Submission Form

Epping to Thornleigh Third Track Proposal. Application number SSI 5132.

Figure S.6 Cross-section and elevation - New Cheltenham Station concourse building (see also S.5 for artist's impression)

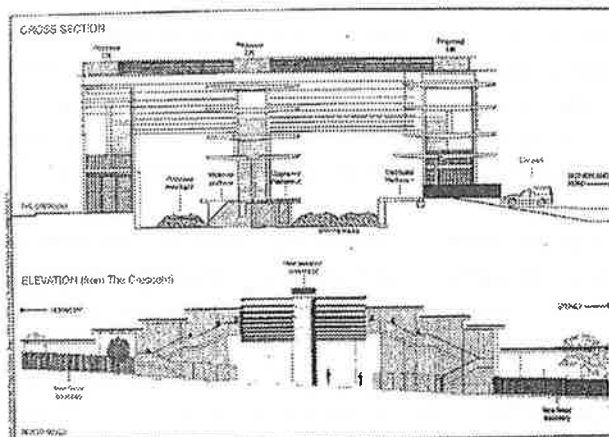
- The proposed redevelopment of Cheltenham Station shows no regard for the HCA. The visual impact of the proposed 13m high glass and steel concourse is totally unacceptable in this HCA.

Figure 5.3 Future Cheltenham Station layout

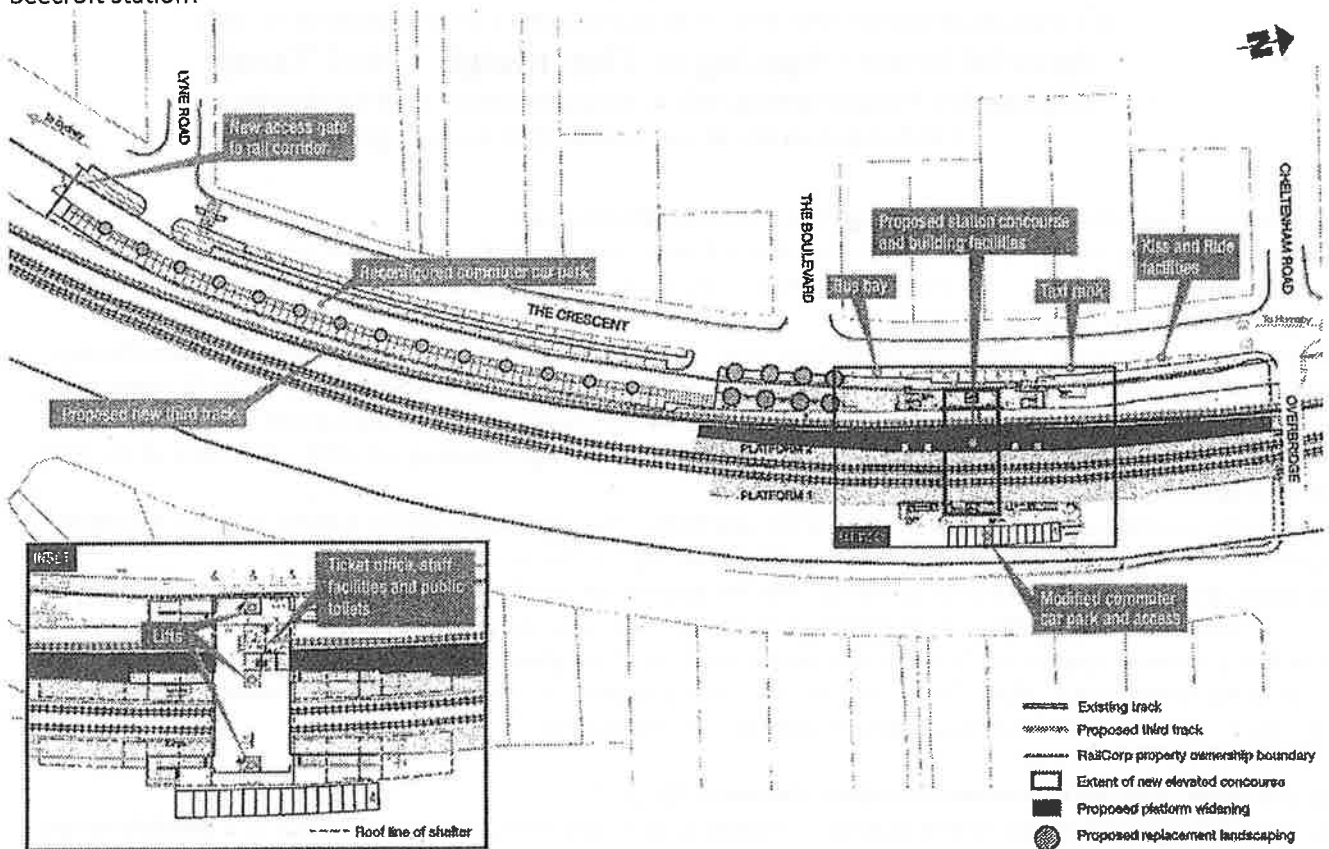
- There has been inadequate assessment of the project's impact on the fabric of the Beecroft Cheltenham Heritage Conservation Area (HCA).
- The plan given for Beecroft Railway station Precinct is vague. The relationship to the trees, playground and original 1895 platform located south of the present station is not shown. A fourth track is shown on the eastern side. The plan does not include urgently needed lifts to allow disabled access at Beecroft Station.
